Application H13-0865-20
Location 7 BROAD LANE MOULTON SPALDING PE12 6PN
Proposal Partial demolition of curtilage listed outbuilding and rebuilding and conversion to annex

Name Ian Marshman, Historic Environment Officer
Address Lincolnshire County Council Lancaster House 36 Orchard Street LN1 1XX

Existing Ground Floor Plan
Scale 1:50

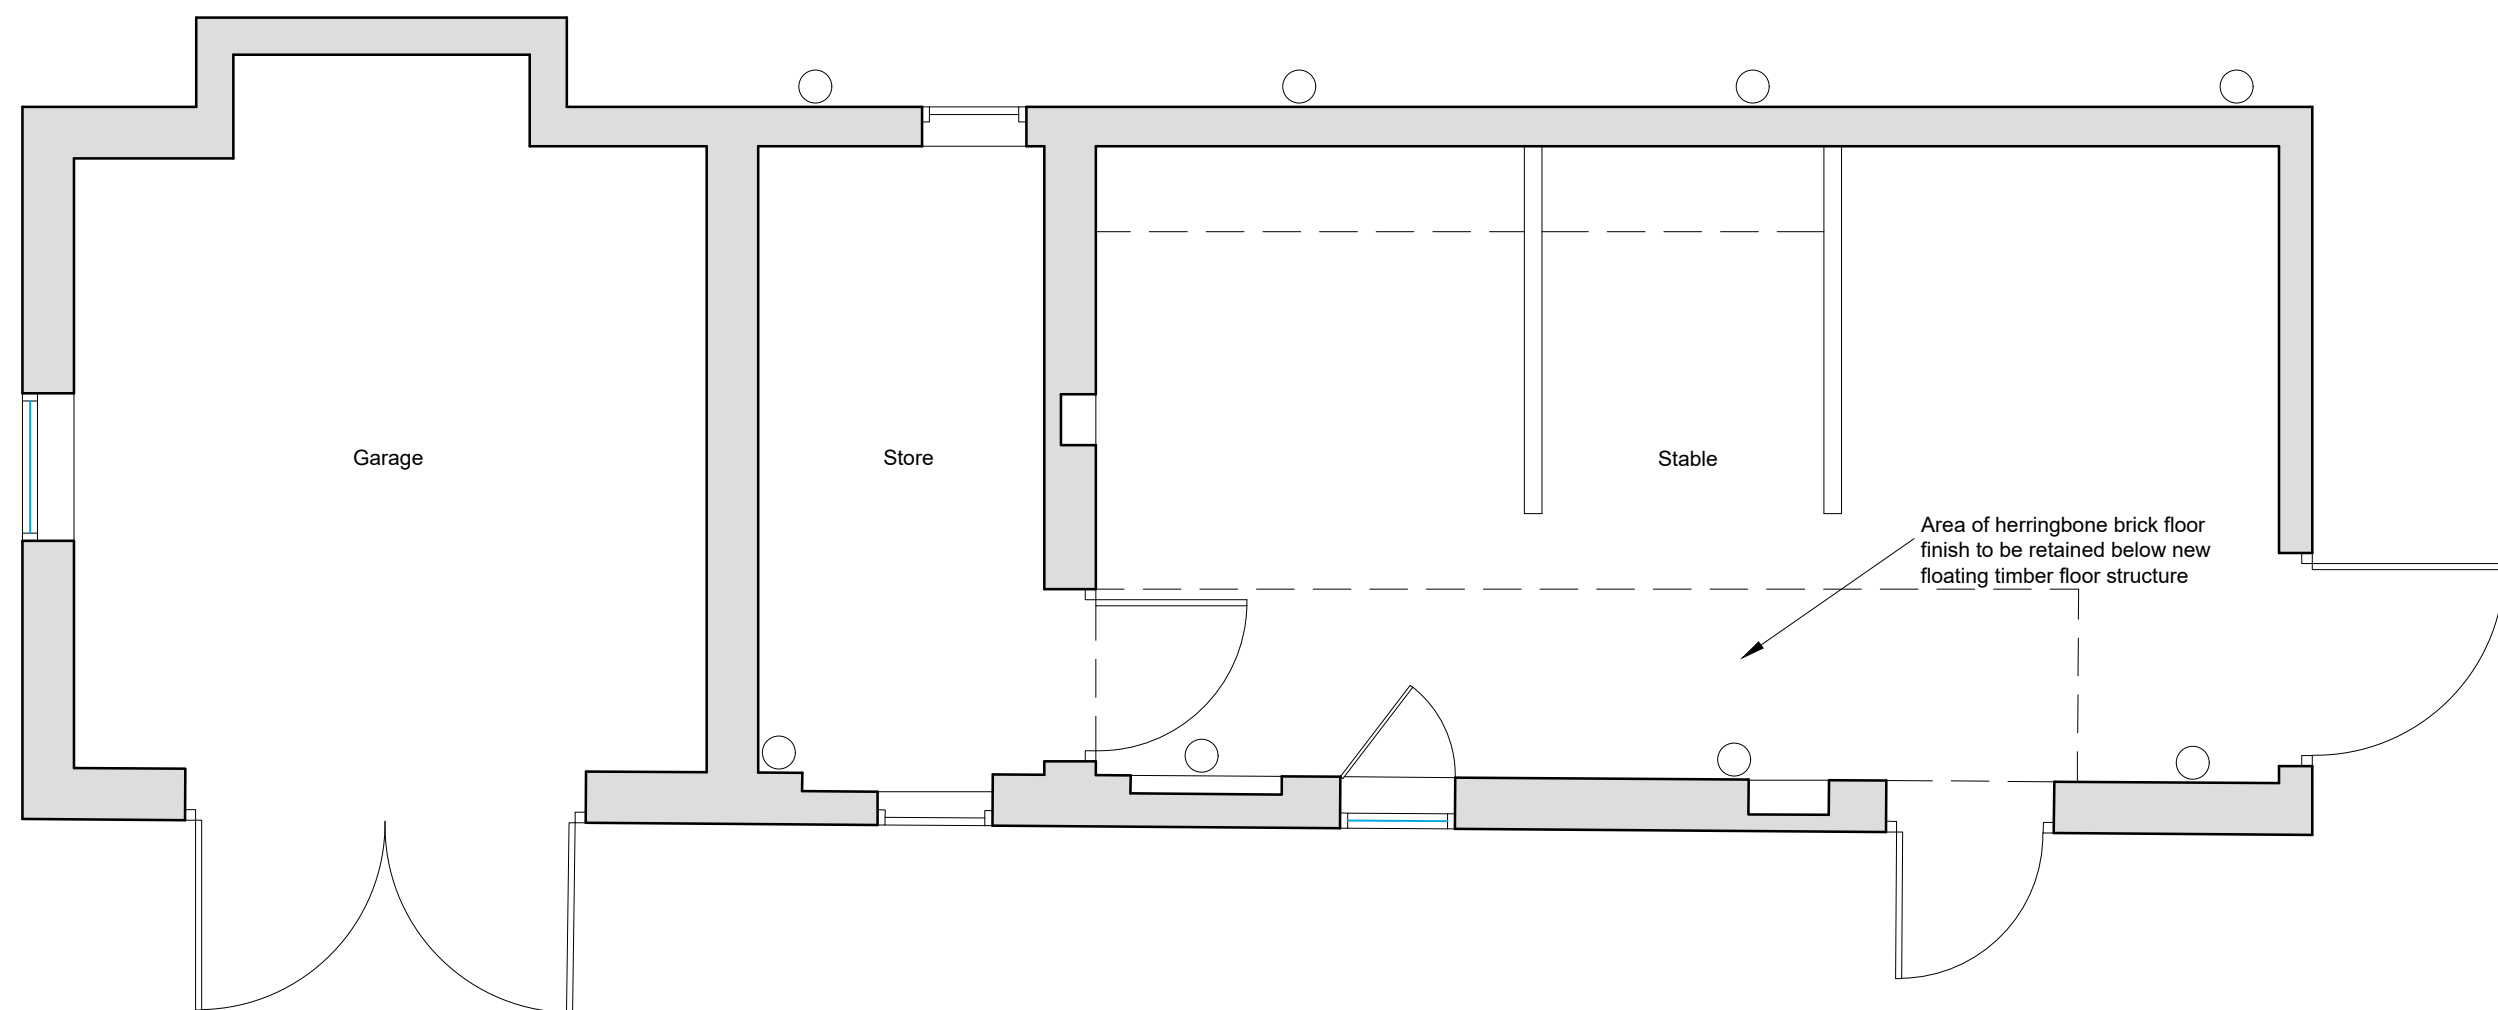
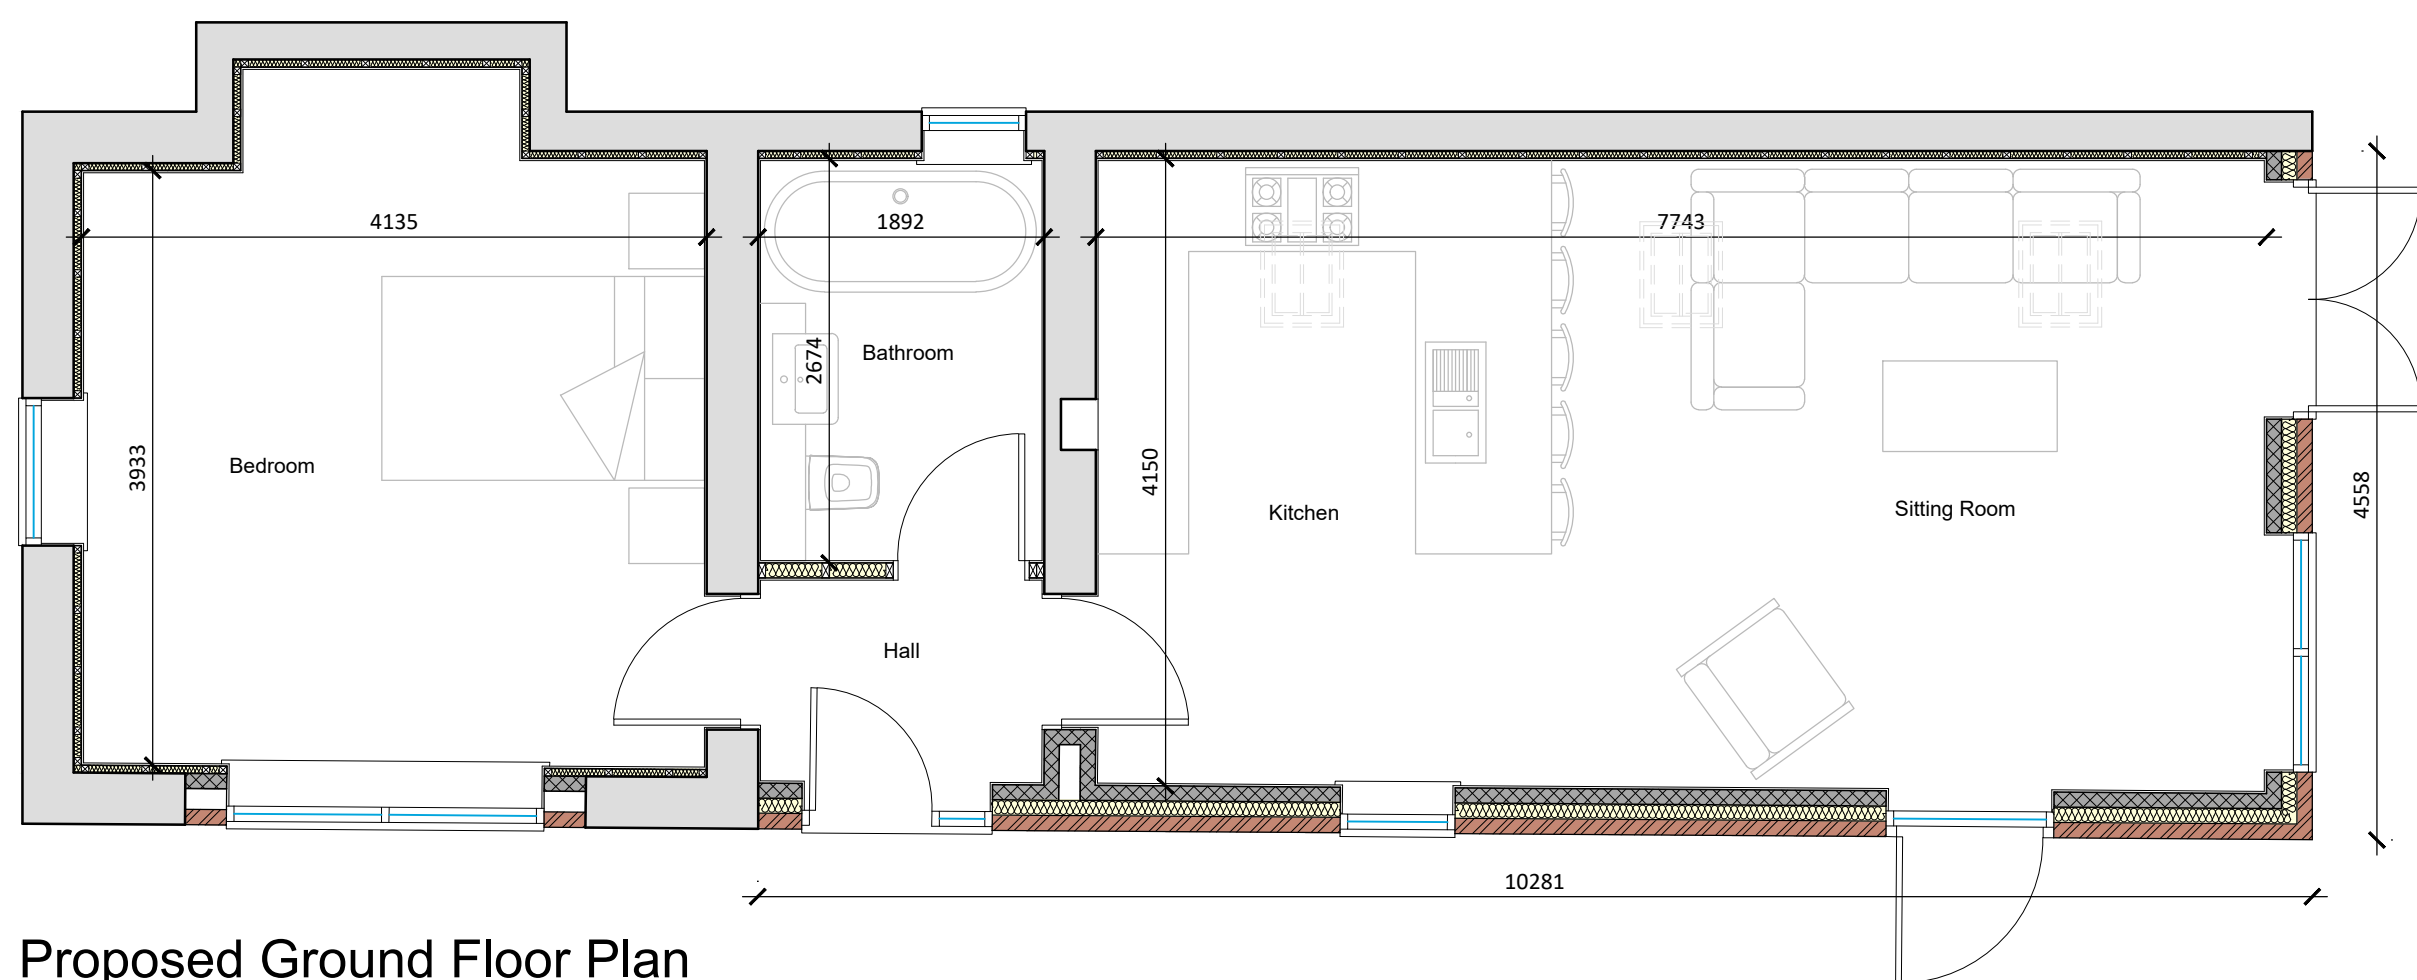
The Heritage Impact Assessment submitted by the developer states that following advice from the local planning authority's Conservation Officer, a photographic record should be made of the wooden stable stalls within the building prior to their removal, and we recommend that a simple photographic record of the building in its current form be made prior to any demolition or alteration.

This should include photographs of the stalls and the mangers, the herringbone floor (to be preserved beneath a proposed suspended floor), as well as historic doors and windows and any other fixtures and fittings that are to be removed or replaced. Each photo should have a caption describing its contents, and there should be no more than two photographs per A4 page to ensure that sufficient detail is visible in the record created.

If this brief photographic record can be provided prior to determination then no condition would be required on the grant of any forthcoming listed building consent or planning permission.
